# CITY OF ALBUQUERQUE

**RE: APS Rankin Training Facility  
Grading and Drainage Plan  
Engineer's Stamp Date 2-16-2016 (File:G15D061)**

A1 GRADING AND DRAINAGE PLAN

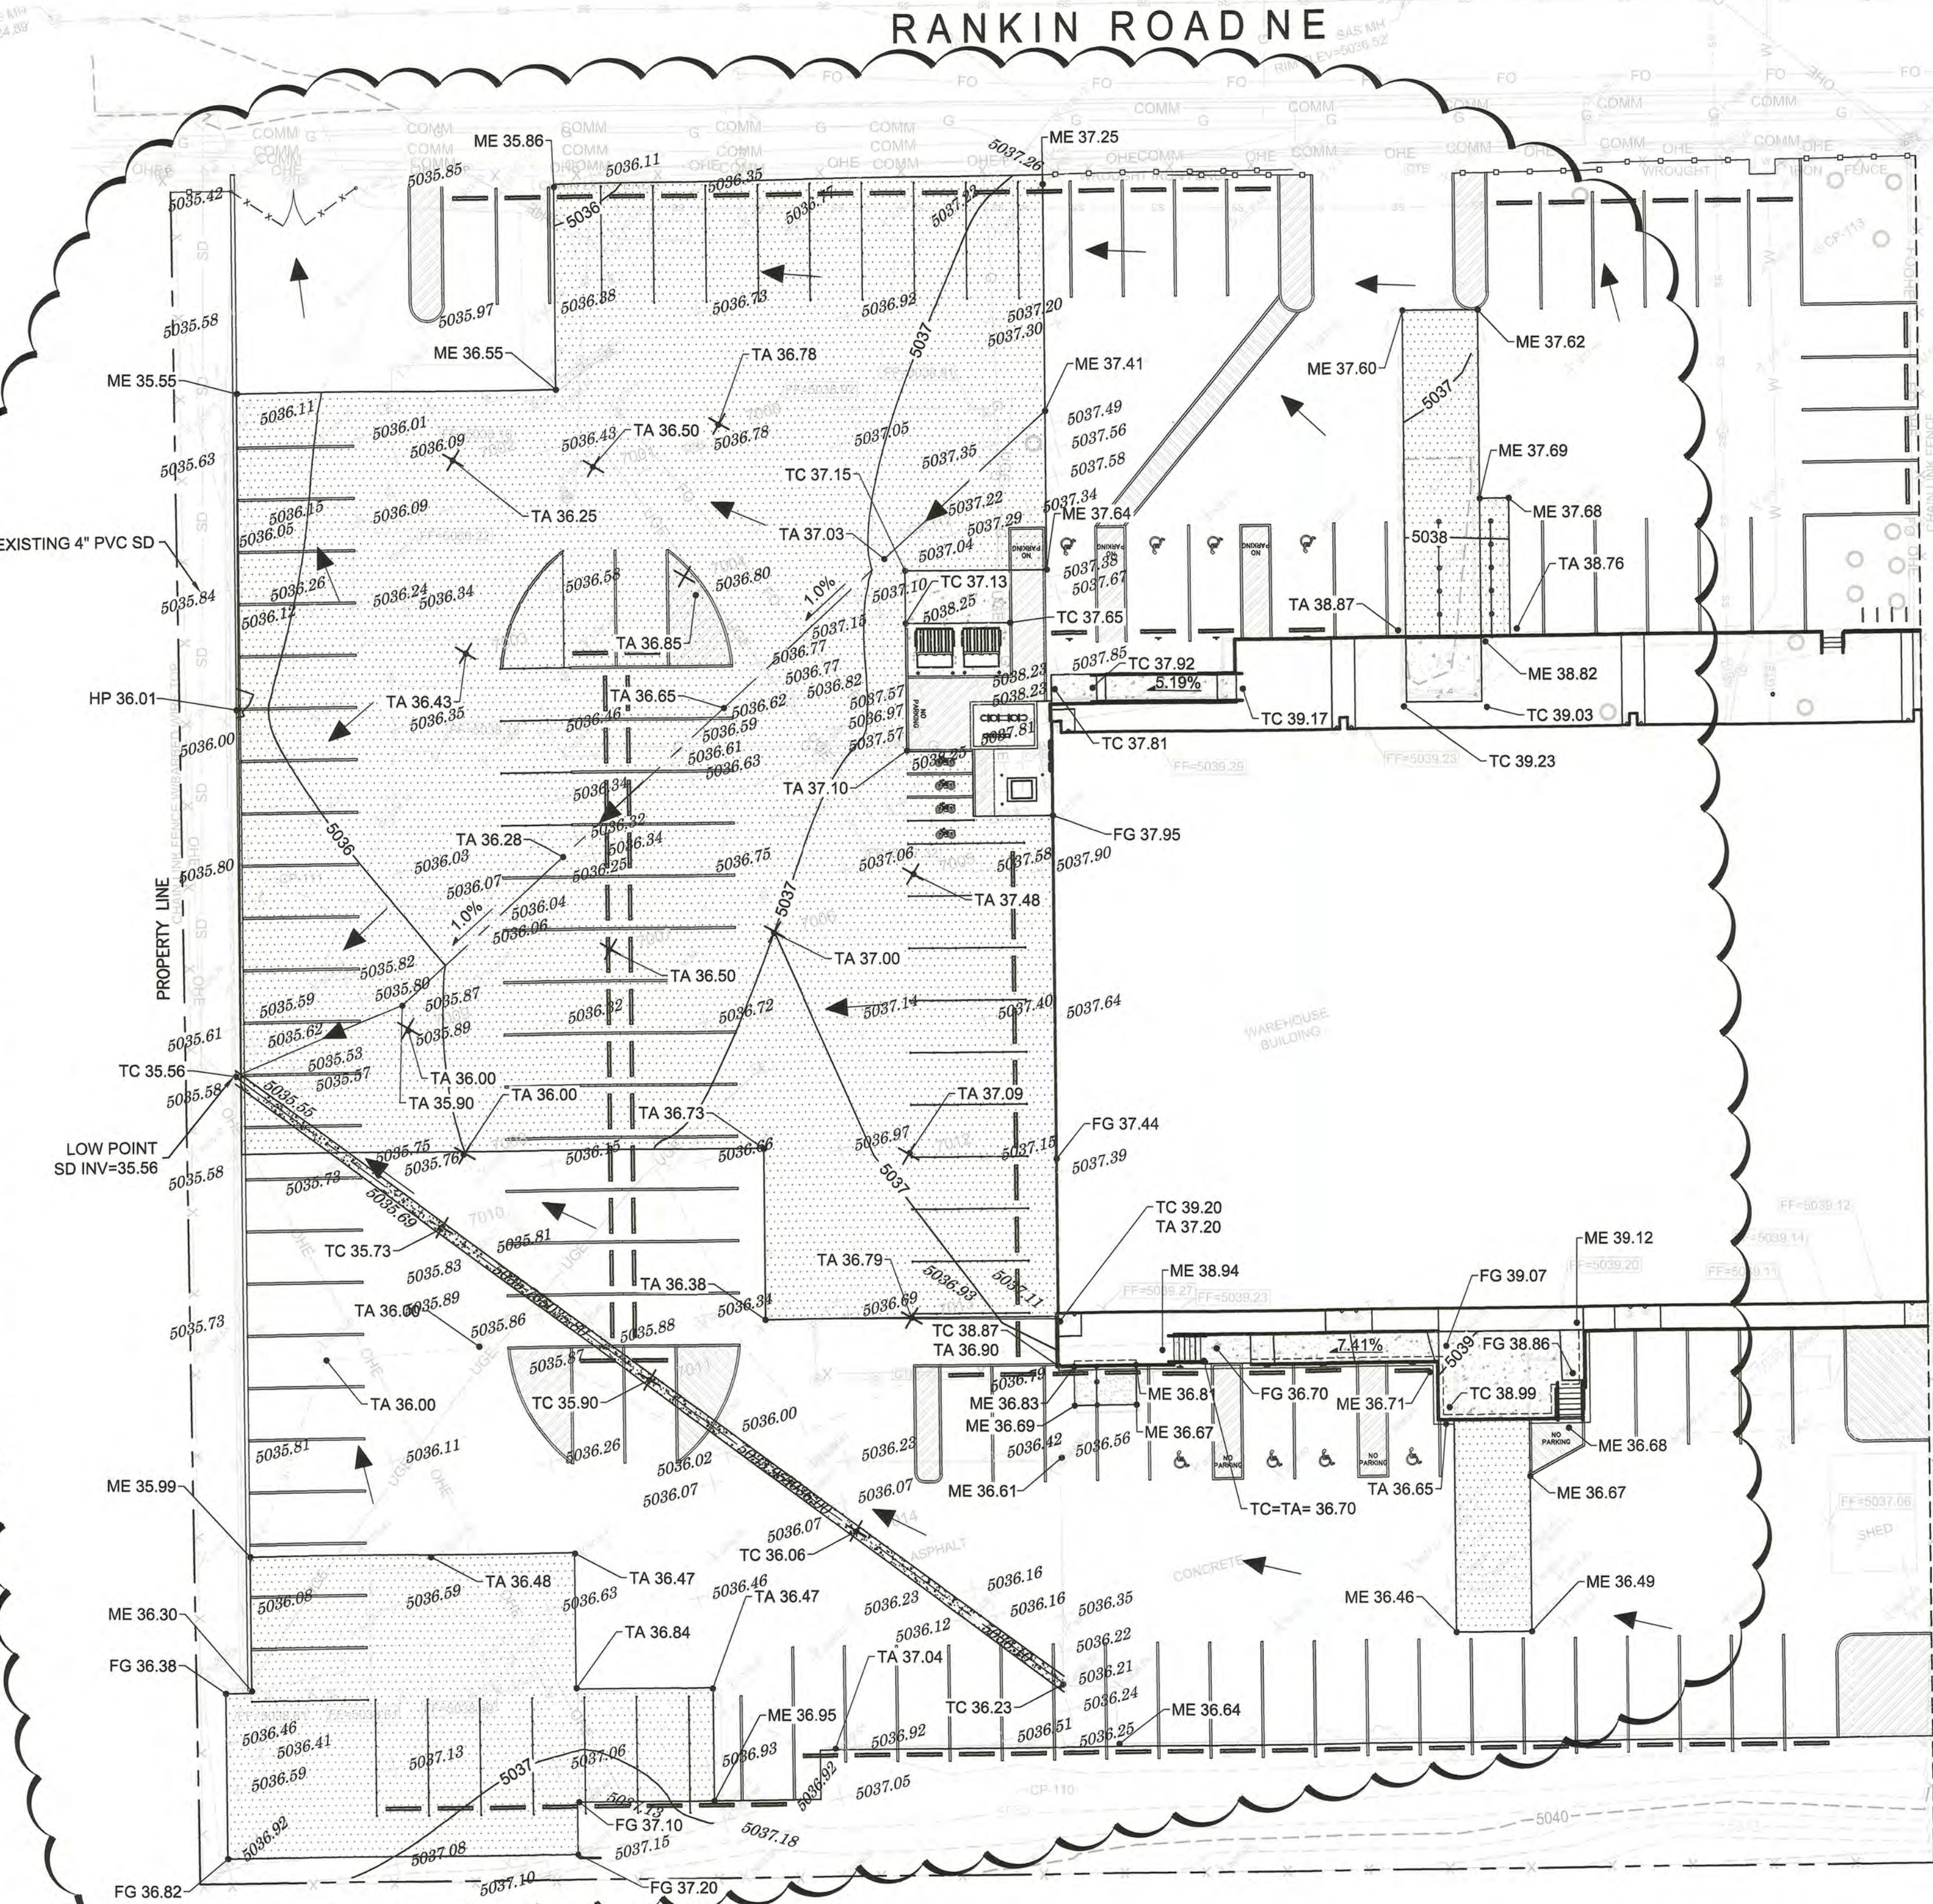
1. The crusher fine parking areas should be graded away from the pavement edges, or the pavement section will be subject to subgrade failure and eventual edge cracking. This will be a requirement, if during the C.O. inspection it becomes apparent that sediment will wash onto the street during a storm.
2. A cut-off wall (or narrow edge curbing) should be considered to maintain the integrity of the new edges of asphalt.
